**KIRKLEES METROPOLITAN COUNCIL
INVESTMENT & REGENERATION SERVICE**

DELEGATED DECISION TO DETERMINE PLANNING APPLICATIONS

| Site Address: | 1000, New Hey Road, Outlane, Huddersfield, HD3 3FJ |
| Description: | Erection of agricultural building and associated works |

PROPOSED ELEVATION A (FRONT)

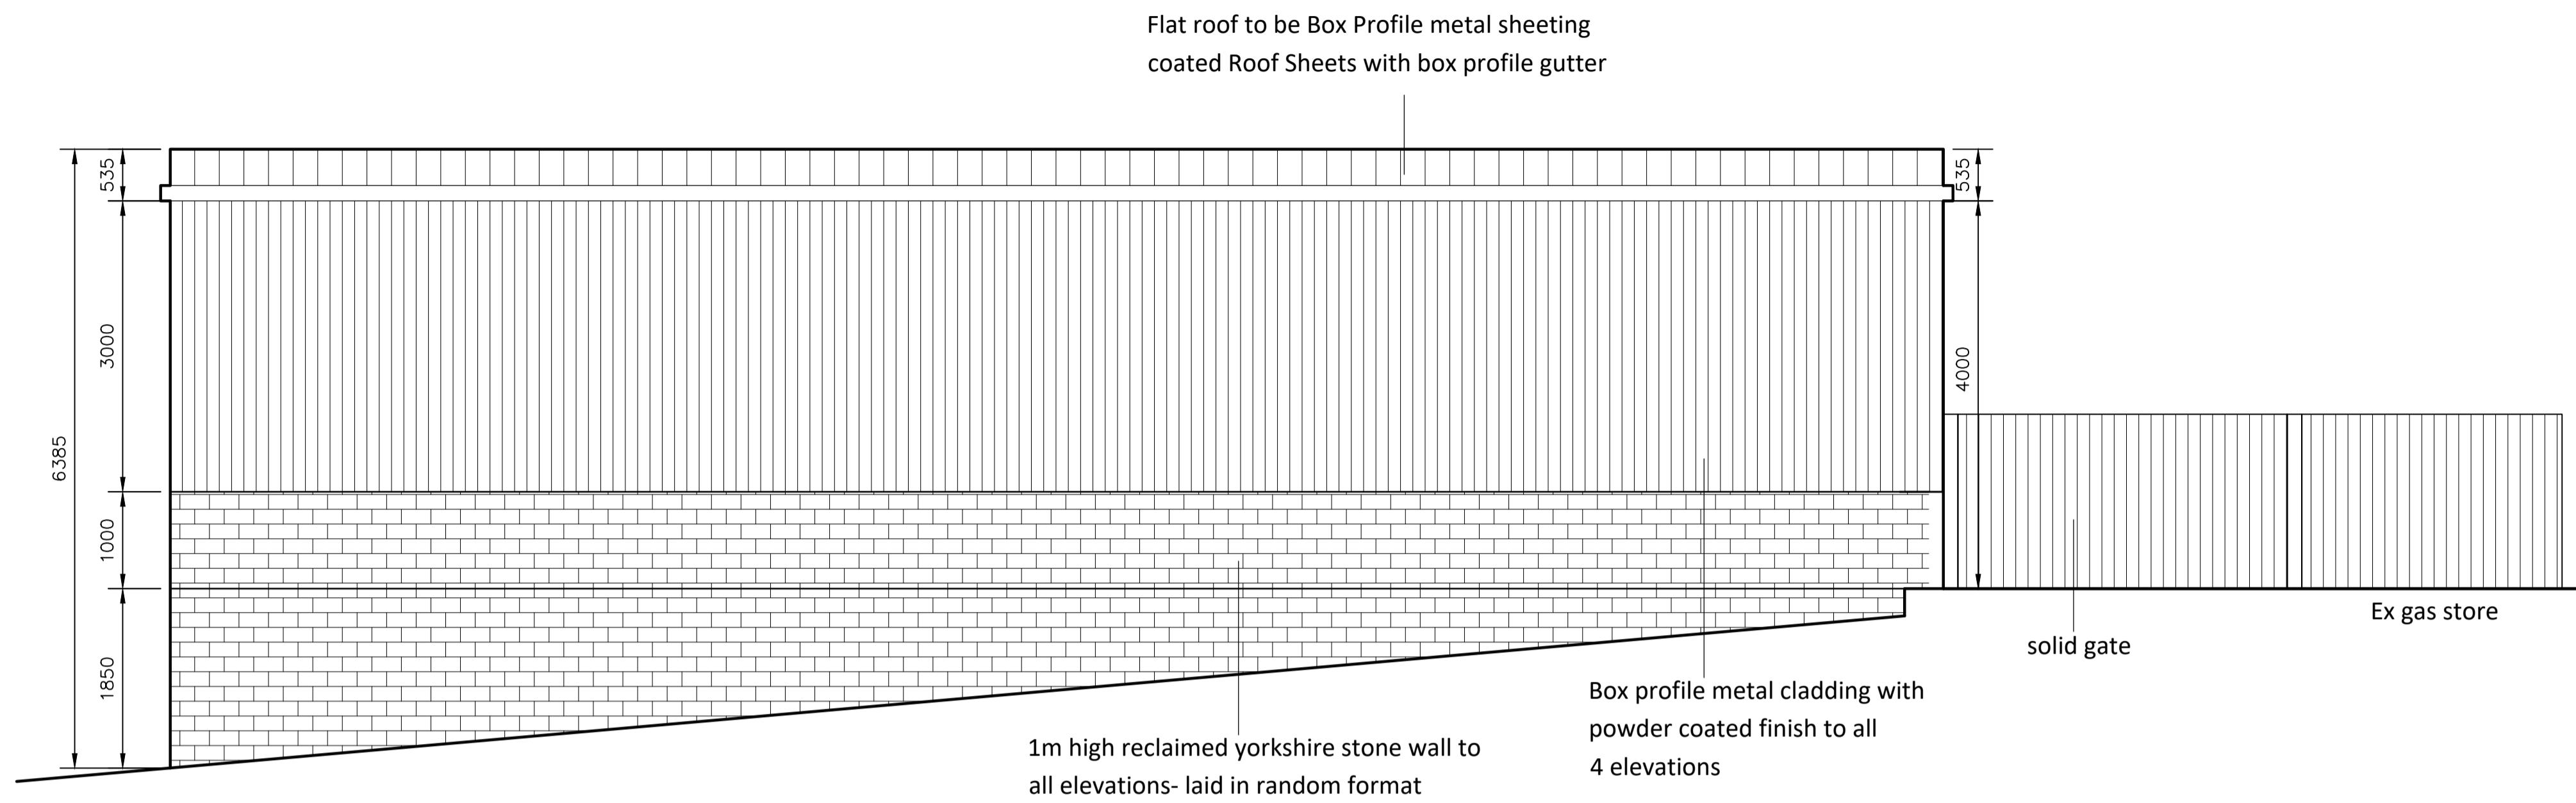
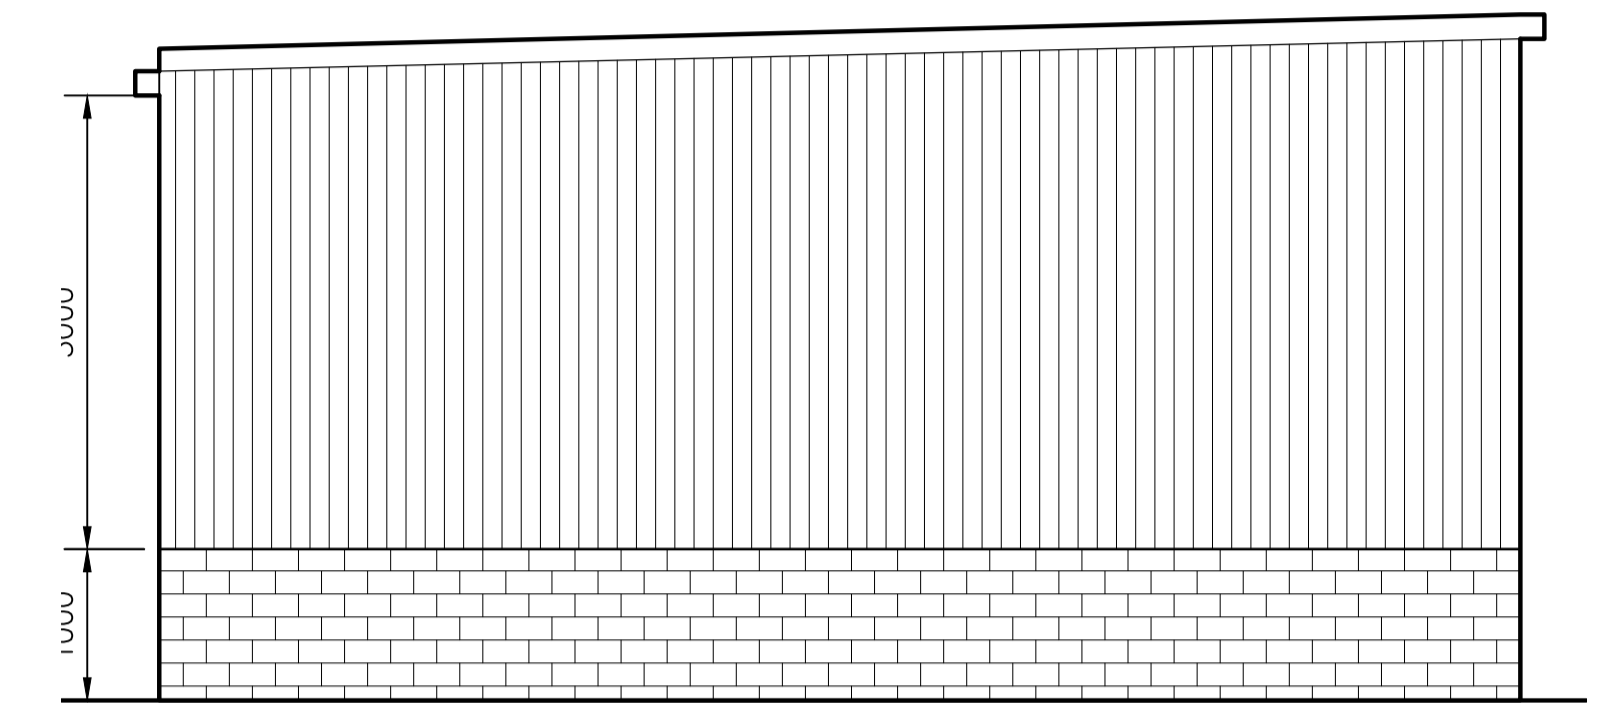
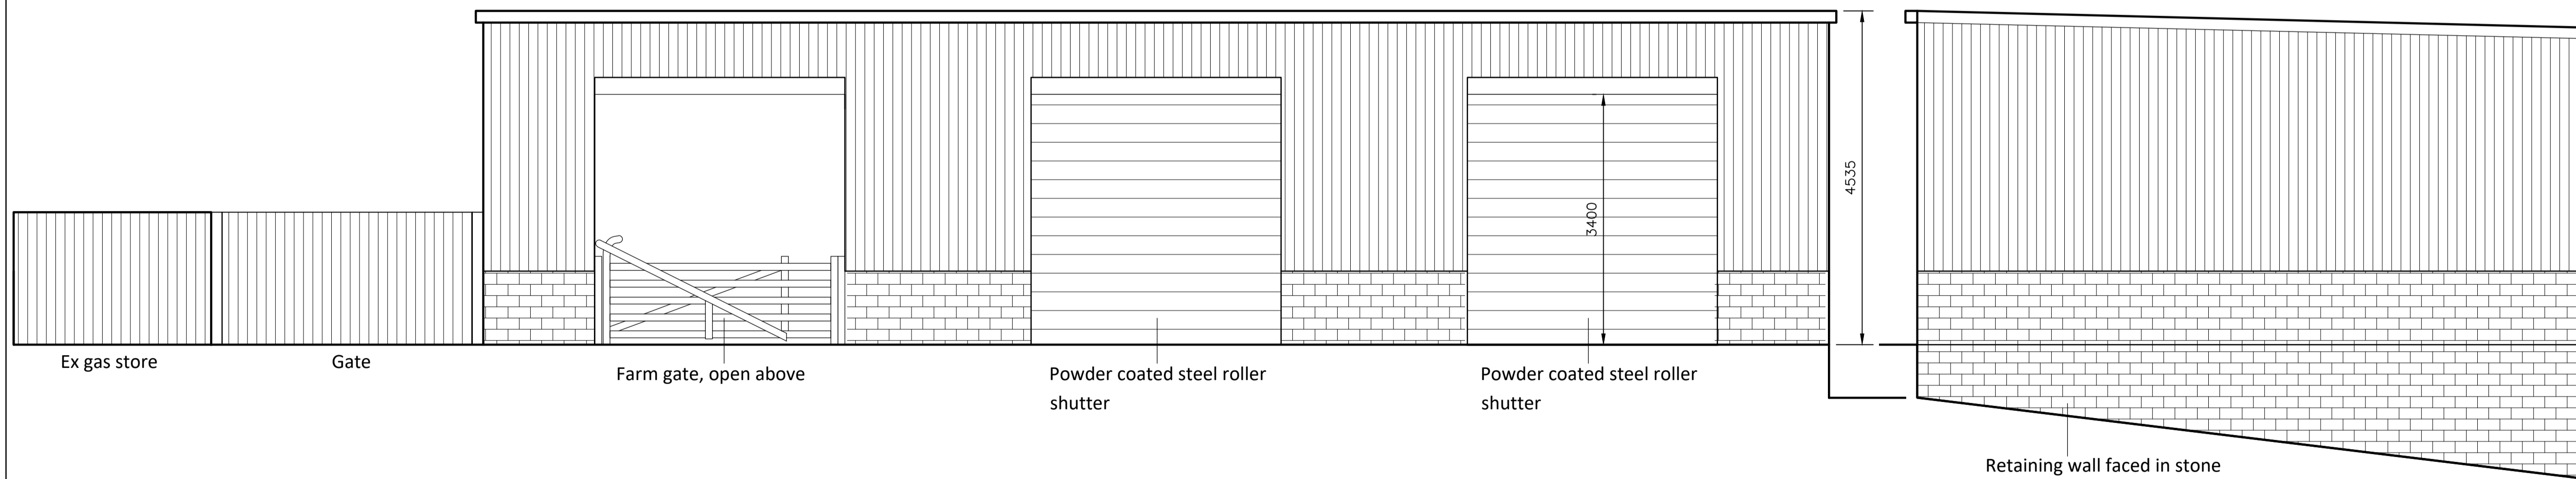
Officers requested the height, scale and level of enclosure of the agricultural building was reduced. The initial plans were for four sections used to store machinery, hay and a drive through section. It was requested if the section used to store hay could be open sided, and the drive through section removed. These requests were made to reduce the harm to the openness of the Green Belt.

- Height of the structure from 6.81m to 4.53m
- Width reduced from 22.00m to 18.20m
- The roller door for the section soring hay has been removed.

- Height of the structure reduced from 6.81m to 4.53m
- Width reduced from 22.00m to 18.20m
- The roller shutter door for the section storing hay has been removed.

DRG No. HD3-02 **SCALE** 1:200 @ A1
DRN BY T.D **DATE** 11/05/2025

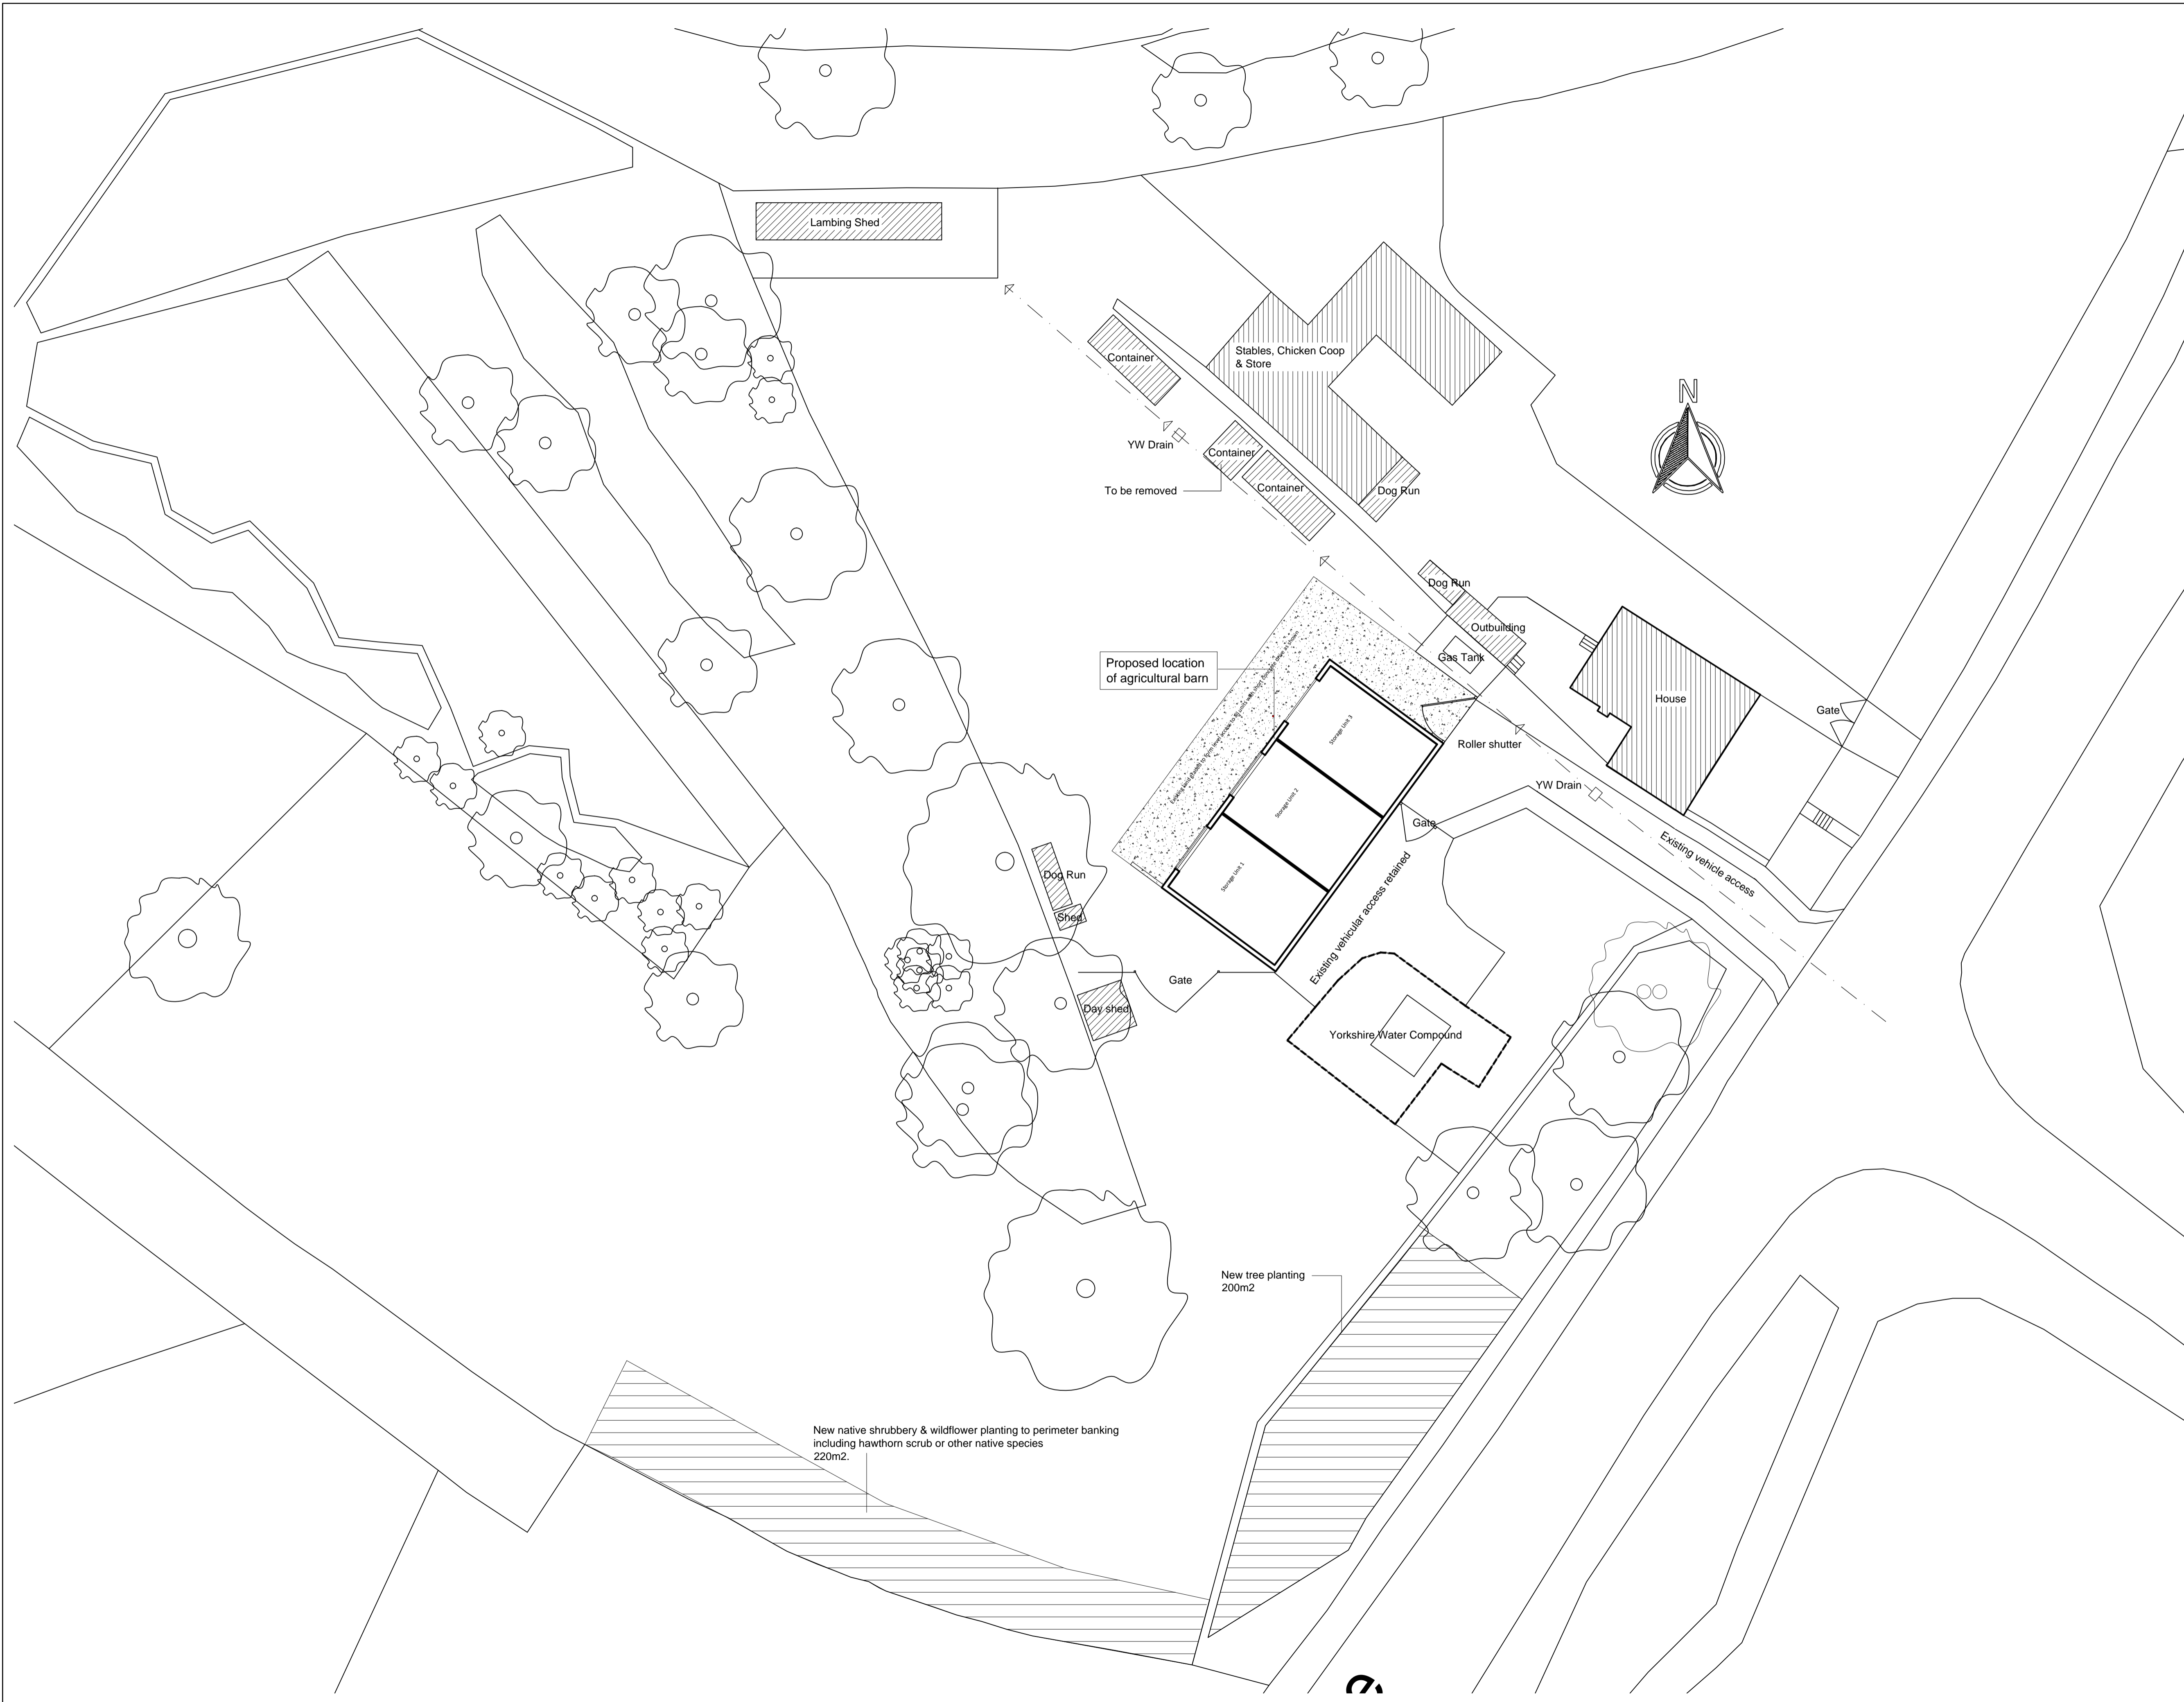
There are a number of storage containers on the site that are used for temporary storage. It was requested the containers are removed and replaced by the agricultural building pursuant to this application. – This was accepted by the agent.

Existing outbuilding on the site include a chicken coup, stables, lambing shed and several containers. It is noted there is limited existing storage for the farming operation, and the yard has been utilised to store much of this machinery. There are several storage containers on site as identified on drawing reference HD3-02 revB.

4. Prior to first use of the building hereby approved, the storage container identified on drawing ref HD03-02 revB received 02 September shall be removed from the entirety of the site.
